RFI

RFI #: 161
Date: 6/25/2012
Job: EB-02 Keller Springs Lofts
Phone: 877-777-5115

Subject: Electrical Outlets Moved for Code

E-2.5

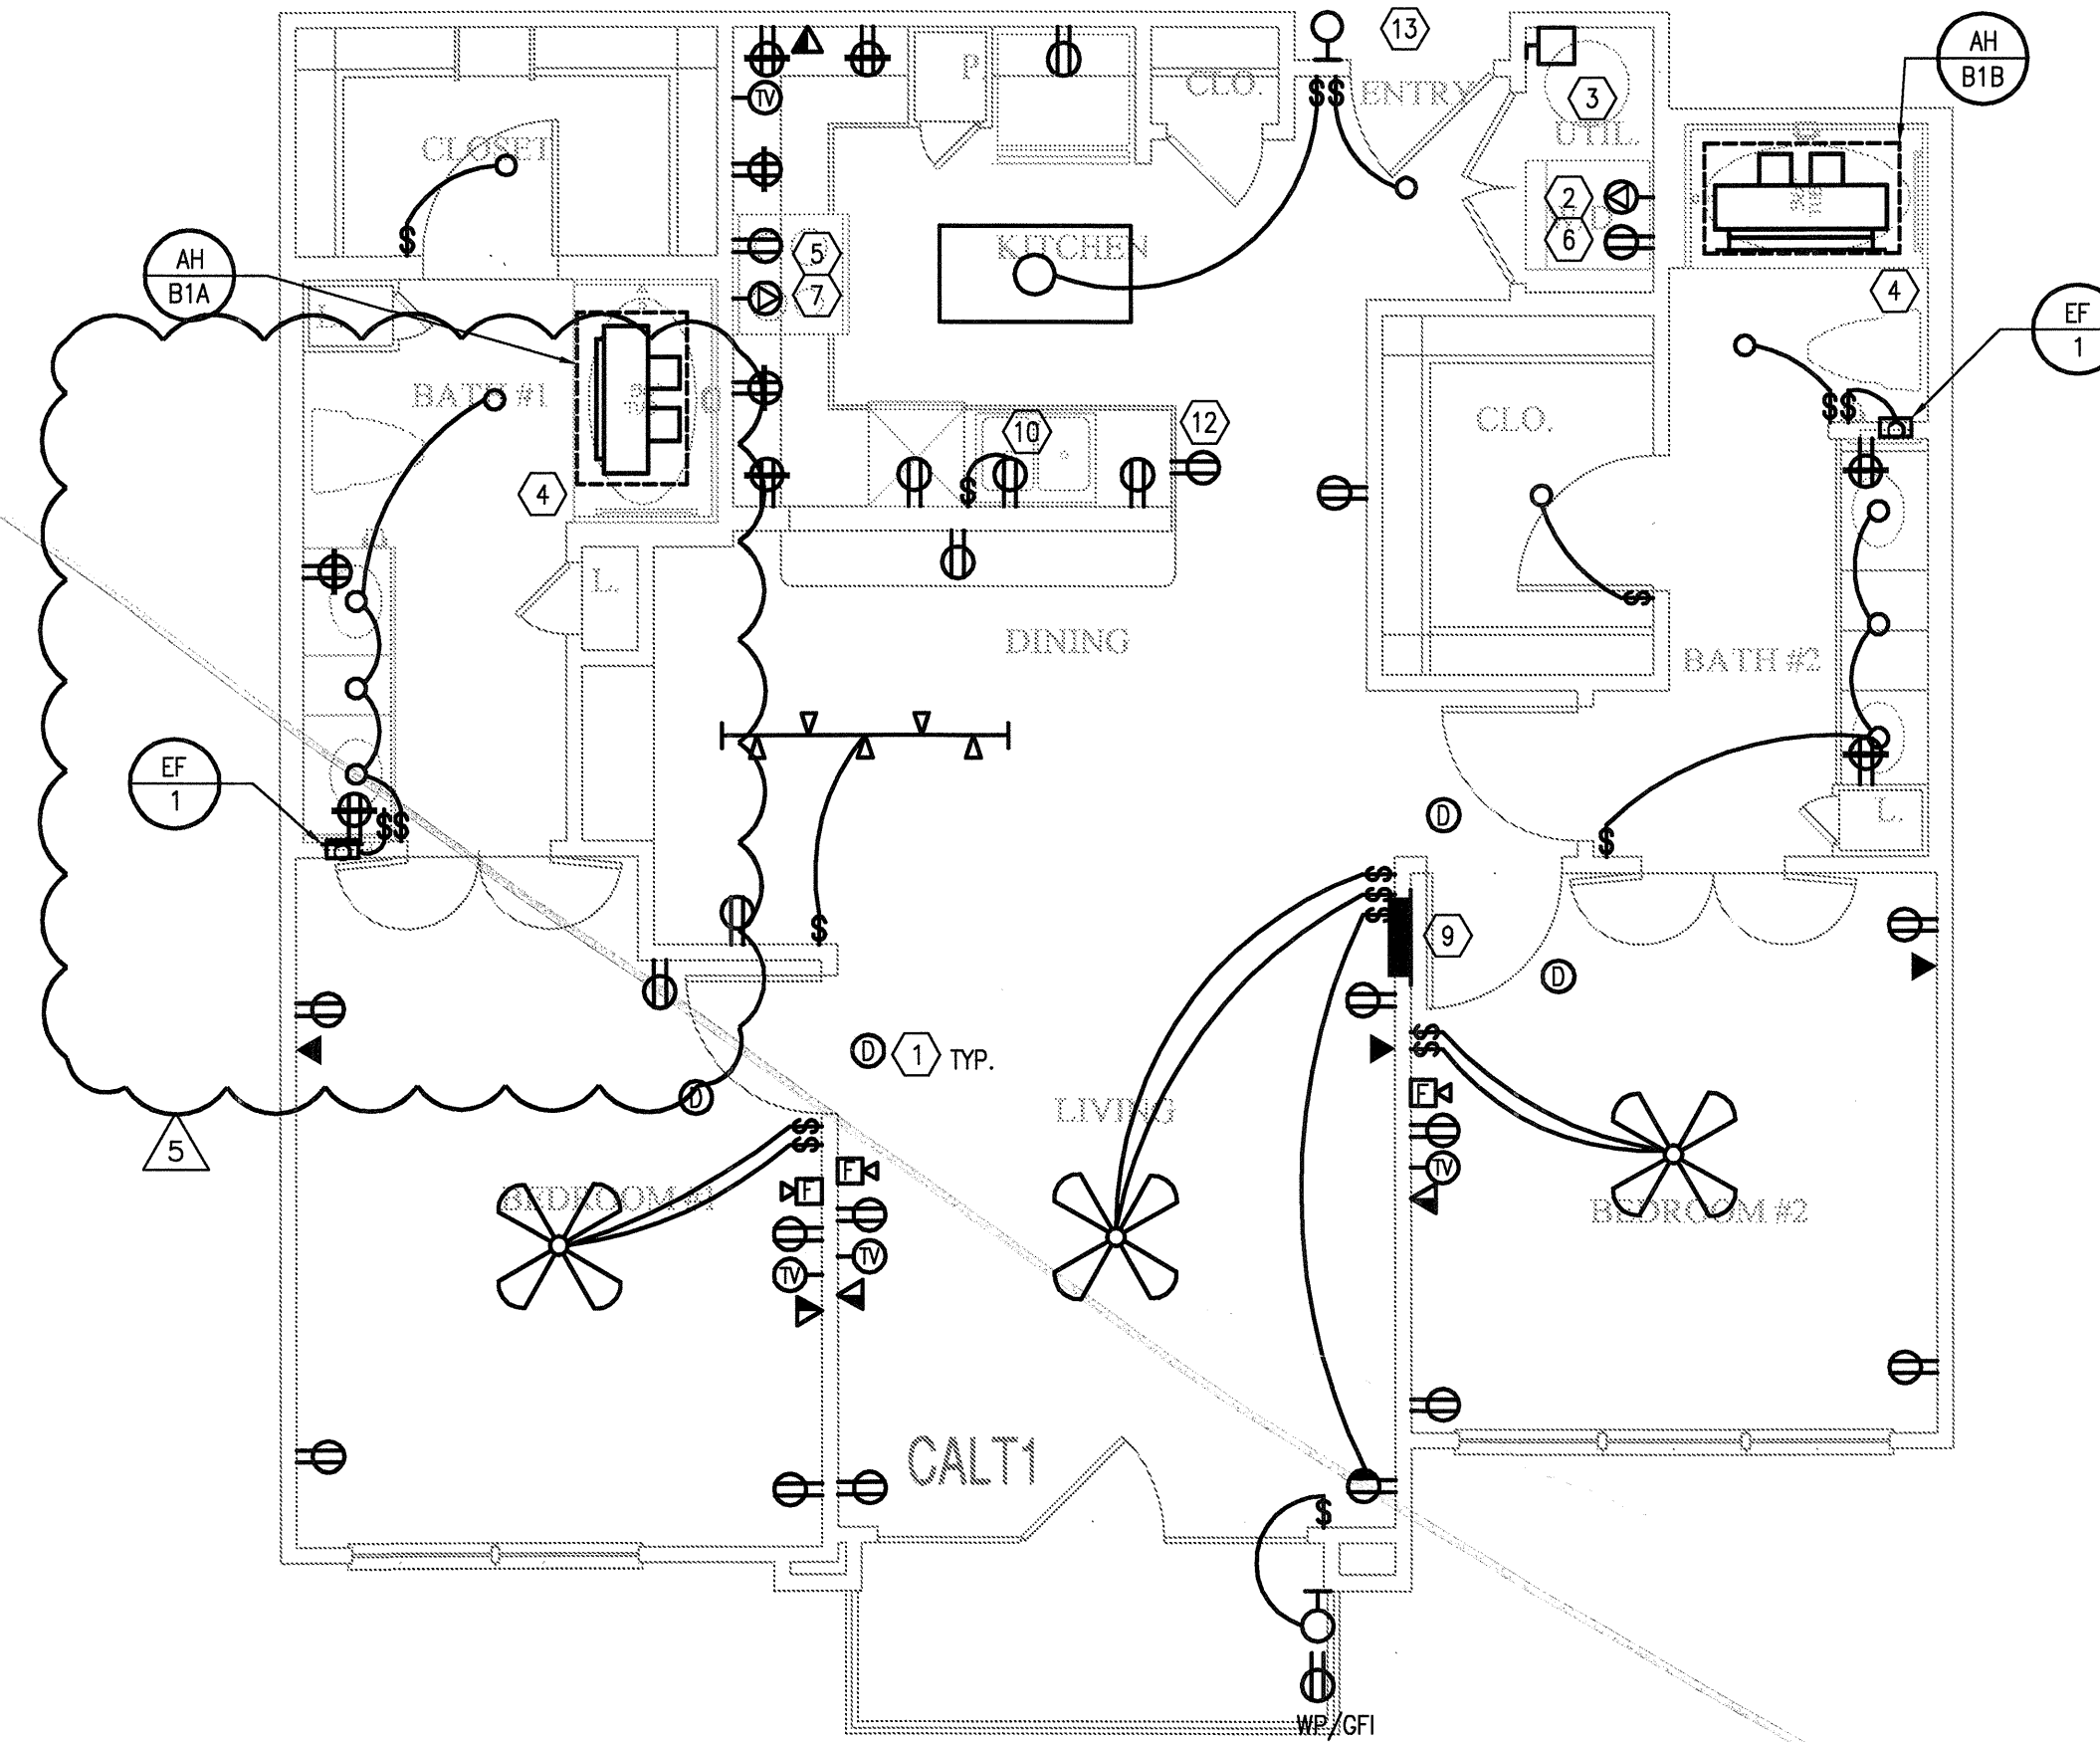
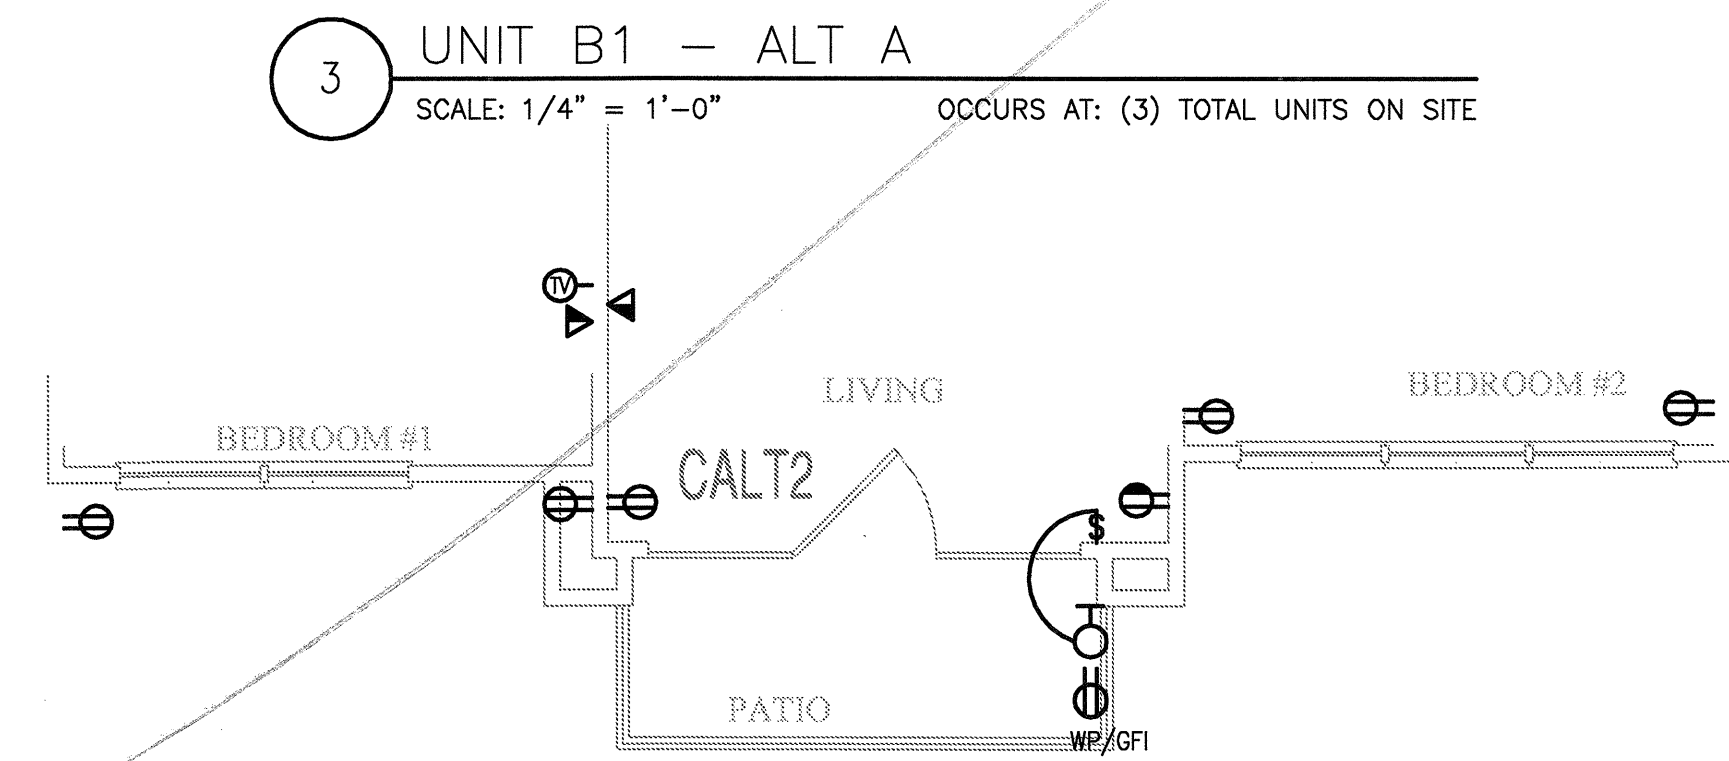
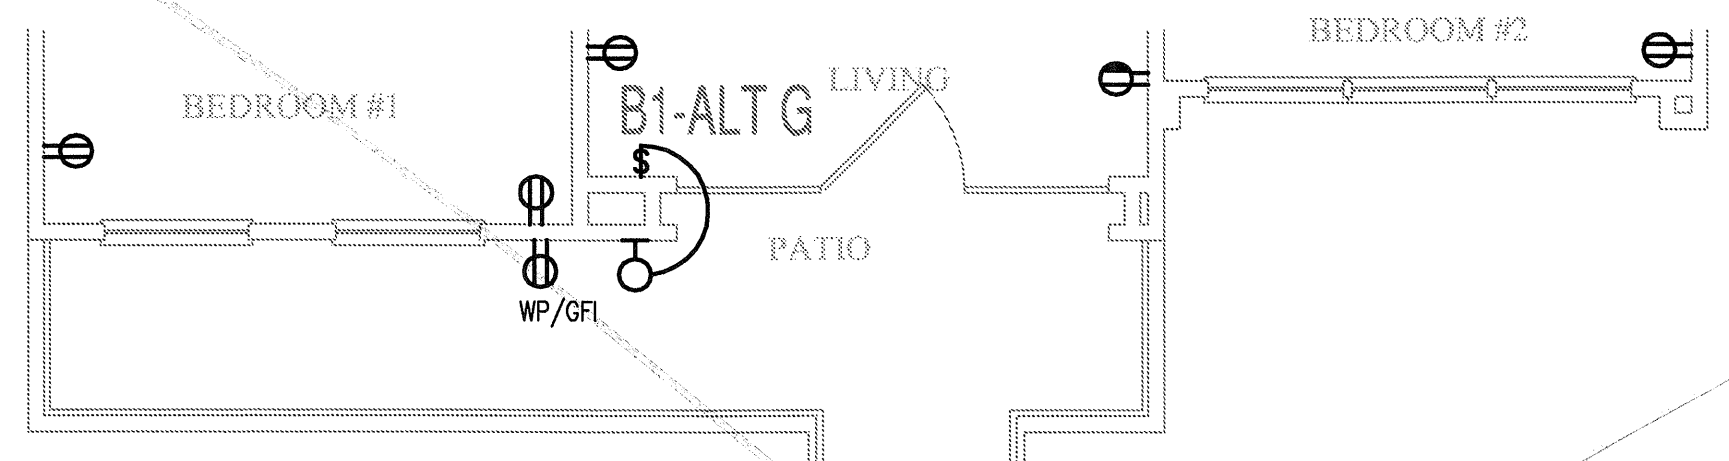
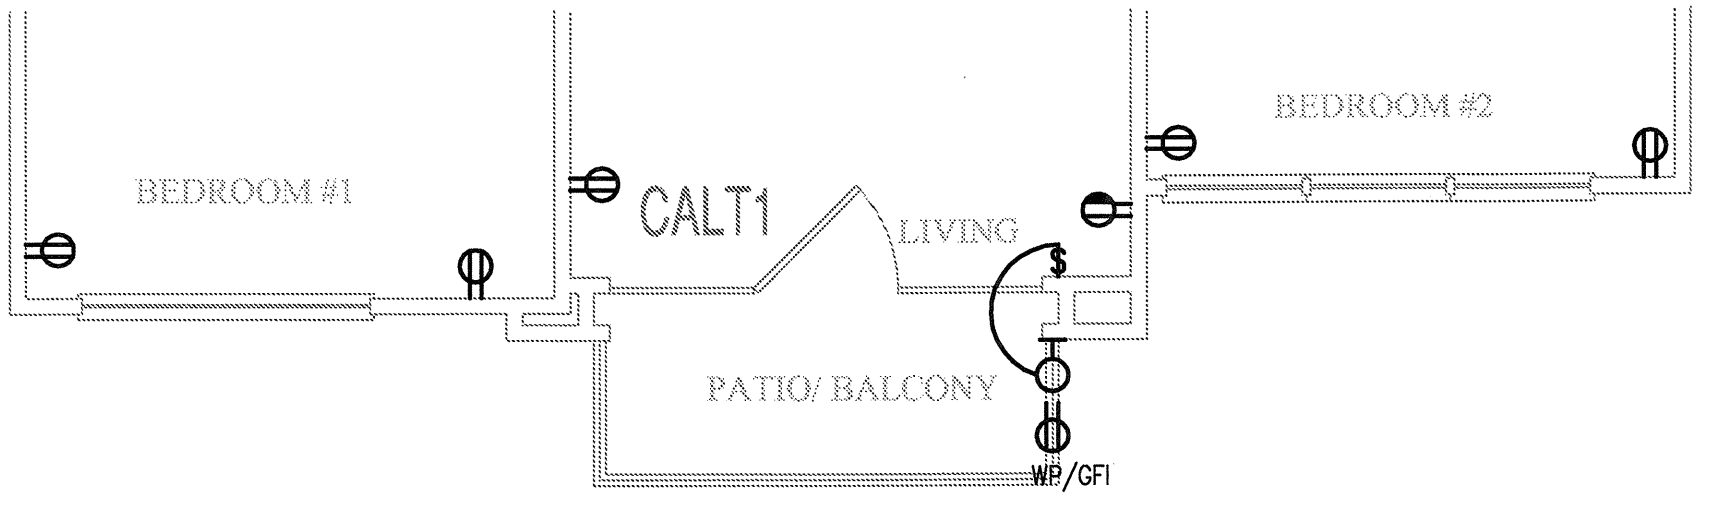
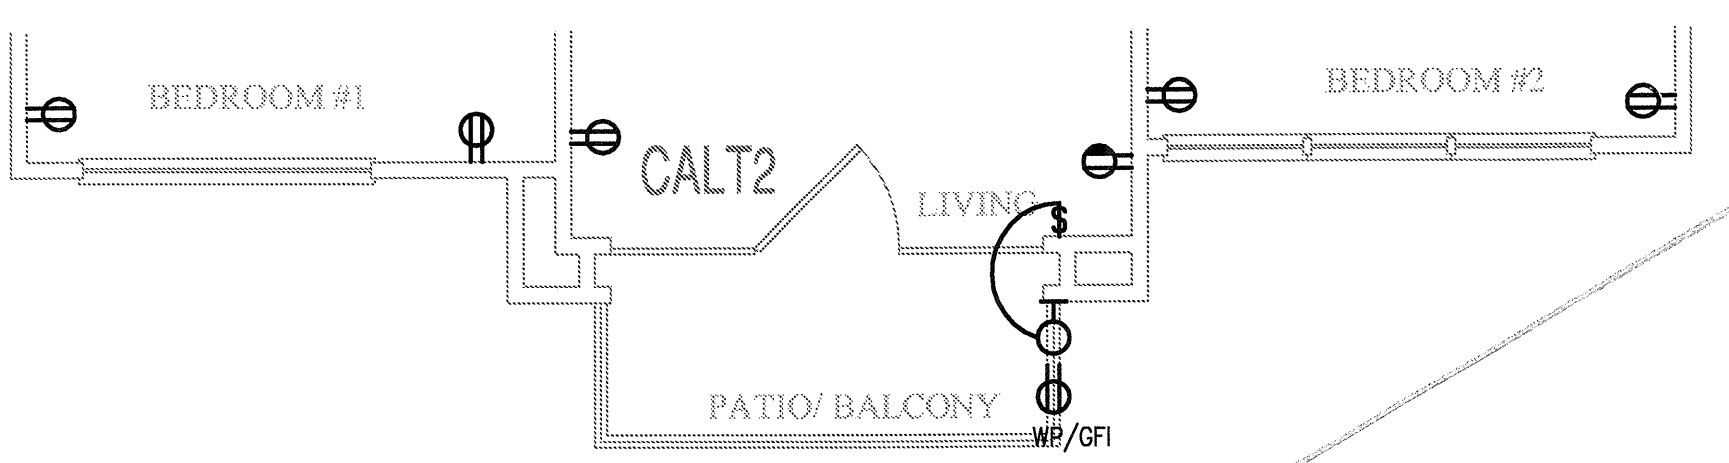
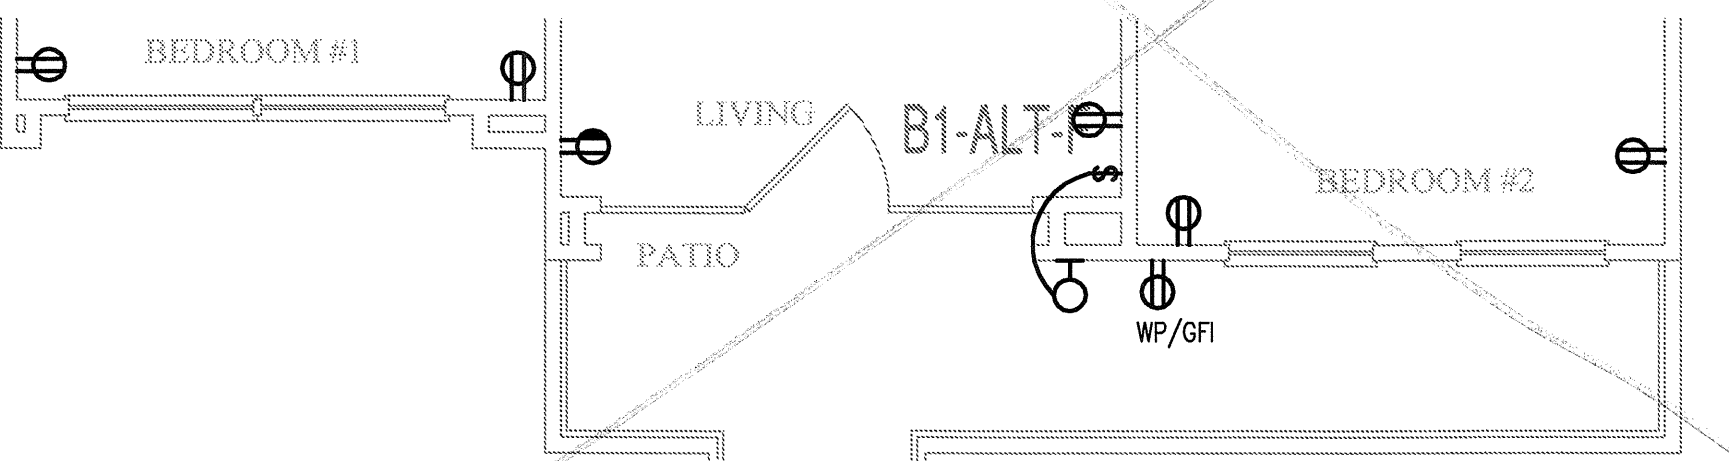
Request: We had an issue at another job where some receptacles needed to be moved in bathrooms due to code. Please check and see if this issue will need to be addressed at this job and revise plans if needed. **Date Required:** 6/26/2012

Reference the attached pdf's showing the correct outlet locations.
